Application for a Non-Material Amendment Following a Grant of Planning Permission

Variation of Condition 2 (approved plans) to allow amendments to planning permission DOV/22/00149 (S73) for alterations to windows and doors to include new fire door to rear, erection of canopy and single storey side extension (existing side extension and metal shutters to be removed)

22/01613

Drawing Proposed Elevations		Date Jan-22	
Project/Client 'Emmaus Phase 2 'Building a Better Future' Trustees of Emmaus		Scale @ A3 1:200	
Job reference Drawing number 02049B 2001		Revision P8	
		Purpose of Issue Information

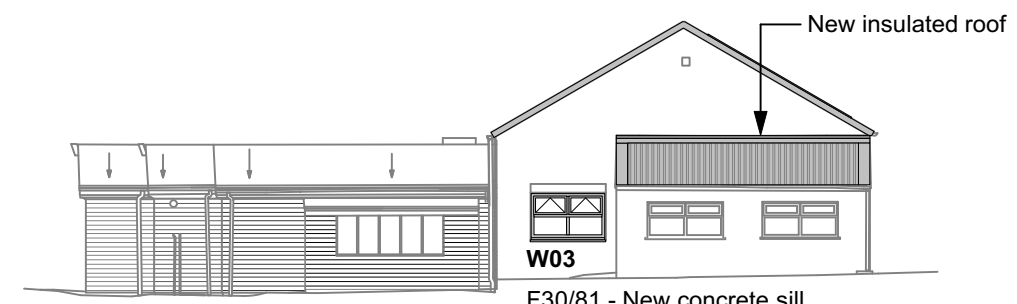
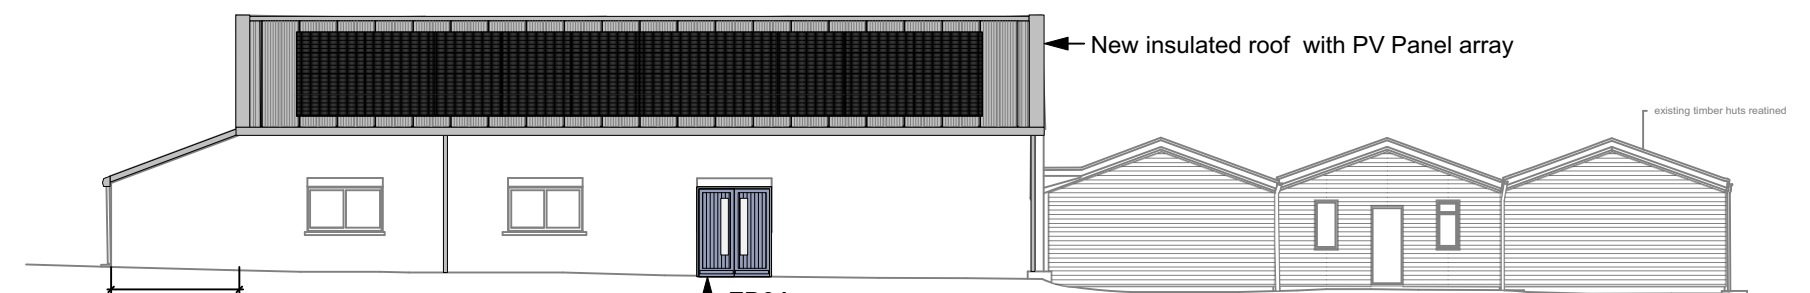
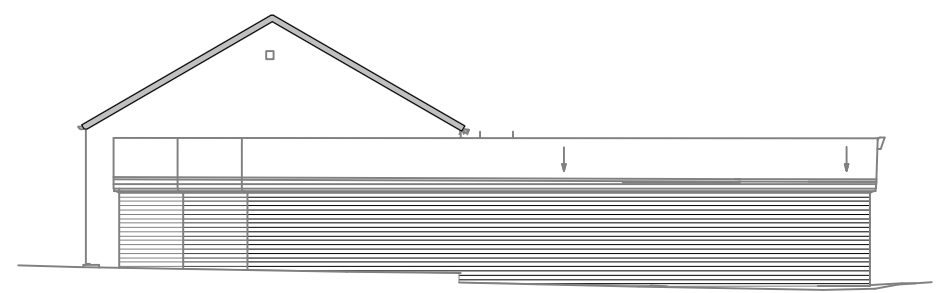
1. Roof colour given in application as Merlin Grey but installed in Goosewing Grey.
2. Solar panels were shown as a Kingspan PowerPanel roof with PV's bonded to the roof but installed as mounted PV system.
3. Main entrance doors extended to full opening width with sliding door rather than outward opening doors.

1. Roofing contractor ordered and installed incorrect panel. We had originally been asked by the case officer to match the existing roof colour, which was Goosewing Grey. To have replaced the roof with Merlin Grey would have substantially delayed the project.
2. Kingspan withdrew their PowerPanel product at the start of the contract.
3. A sliding door was considered preferable on safety grounds due to the exposed nature of the site.
